WEST SUSSEX COUNTY COUNCIL CONSULTATION

TO:	Arun District Council FAO: Emma Sheppard
FROM:	Stephen Gee WSCC – Highways Authority
DATE:	14 August 2025
LOCATION:	Land to the West of New Courtwick Lane Wick BN17 7RZ
SUBJECT:	LU/72/25/OUT Hybrid Planning Application comprising of the following: 1)-Outline application with all matters reserved (except access) for Phase 2 (West of Site) comprising development of approximately 8,800sqm GIA Light Industrial/Storage and Distribution (Use Class E(g)(iii) / B8), and 2)-Full Application for Phase 1 (East of the Site) for a food store (Use Class E(a)), 2 No Drive-Thru food/beverage units (Sui Generis) with revised vehicular access, associated parking and landscaping. This application may affect the setting of a listed building and is in CIL Zone 2 and is CIL Liable. Substitute Plans received.
DATE OF SITE VISIT:	n/a
RECOMMENDATION:	More Information

Figure 7 - Proposed Site Masterplan

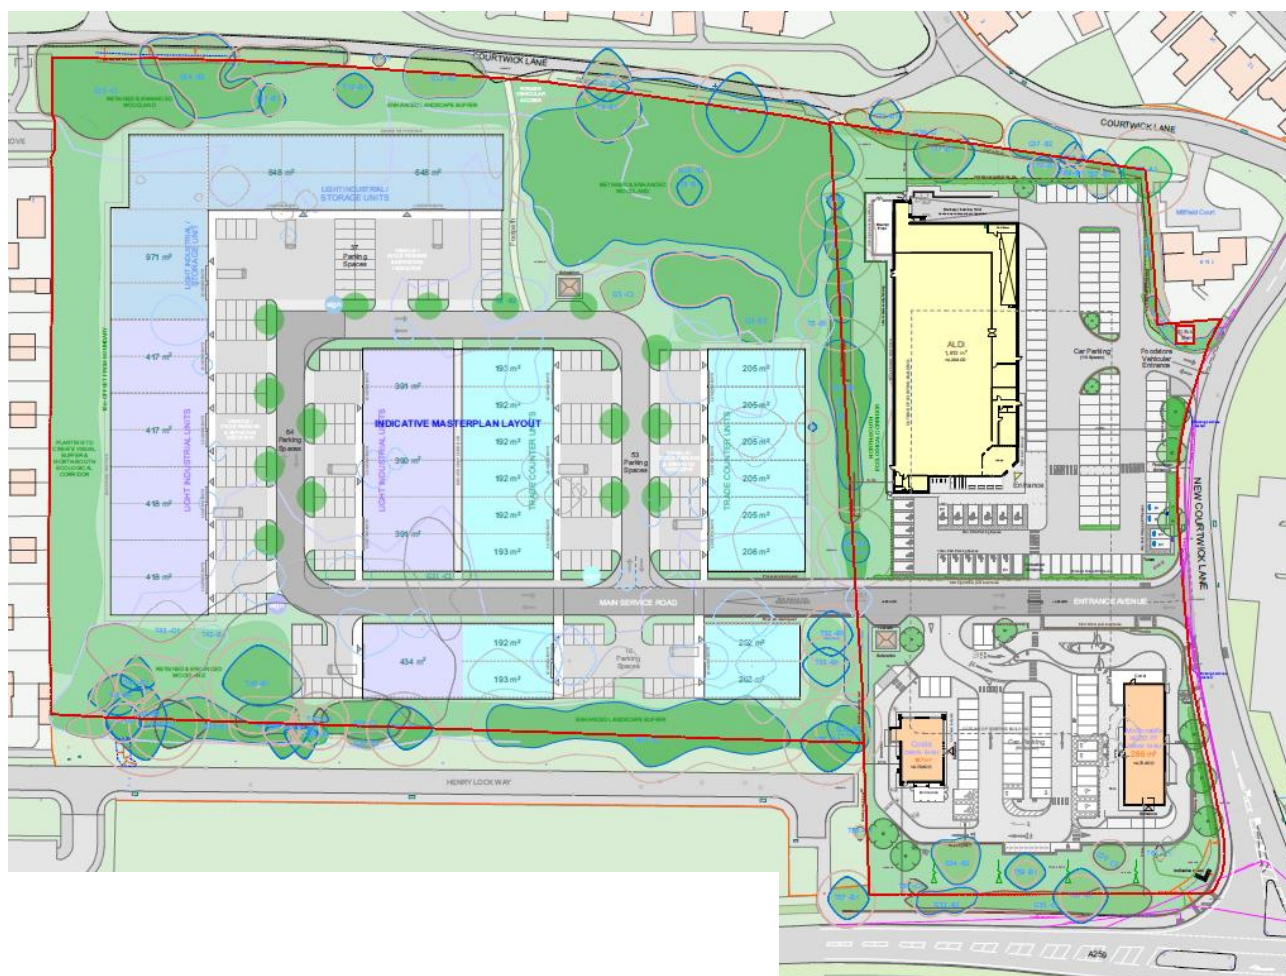
The Proposed Site Plan ref Phase 2 2255-P-011D now does not show the proposed footway link. This would significantly reduce the permeability of the site for pedestrians. Information should be provided to detail the access rights the application site has onto Courtwick Lane and how a link could be secured.
